City of Albuquerque Stormwater Construction Site Inspection Report

Project Name and Location	Apartments 3308 4th St NW		
Site Contact Name & Agency	Jose Rodriguez J & S Development	ESC File No. NPDES ID No.	H14E104
Date of Inspection	2-11-19	Start/End Time	8:10:30 / 10:45
COA Inspector Name	Curtis Cherne, Stormwater Quality		
Describe Present Phase of Construction	Framing 2nd story		
Type of Inspection:	<input checked="" type="radio"/> Regular <input type="radio"/> During storm event <input type="radio"/> Post-storm event (> 0.25 inch) <input type="radio"/> 311 / Complaint Response <input type="radio"/> Follow-Up

EROSION AND SEDIMENT CONTROL PLAN

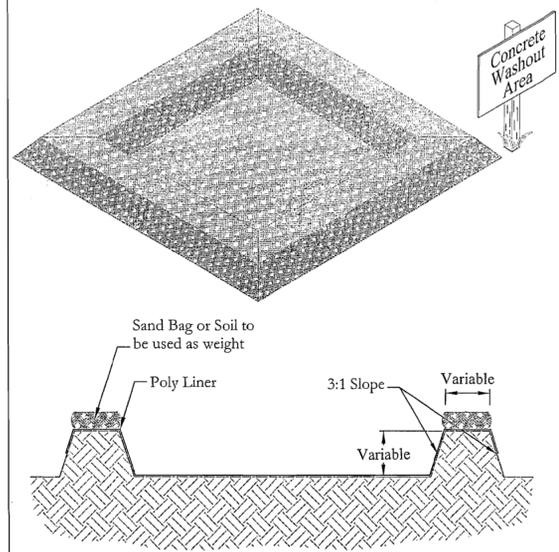
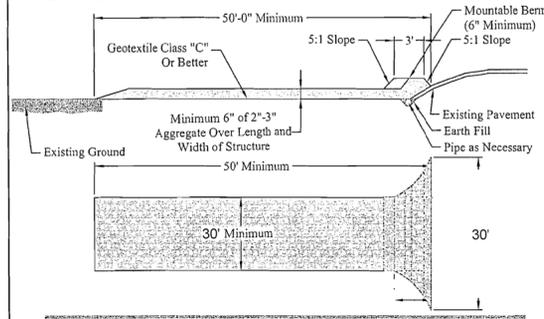
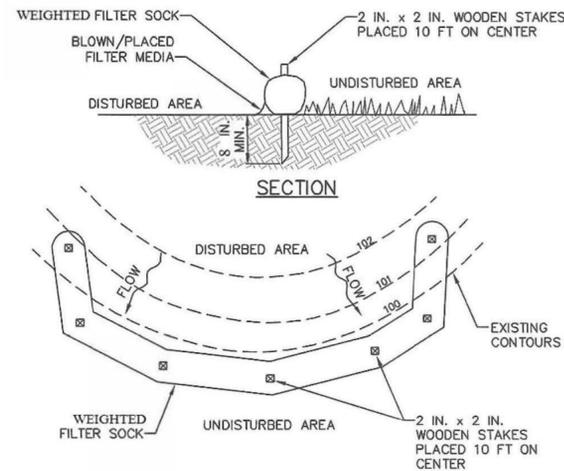
2.3.3	Fuel, oil, hydraulic fluid, petroleum products and chemical storage		
2.3.3	Construction and Domestic Wastes	✓	dumpster not covered / no ability to cover trash rear of bldg

Dumpster is full

Maintenance or corrective actions are to be completed within 7 days.
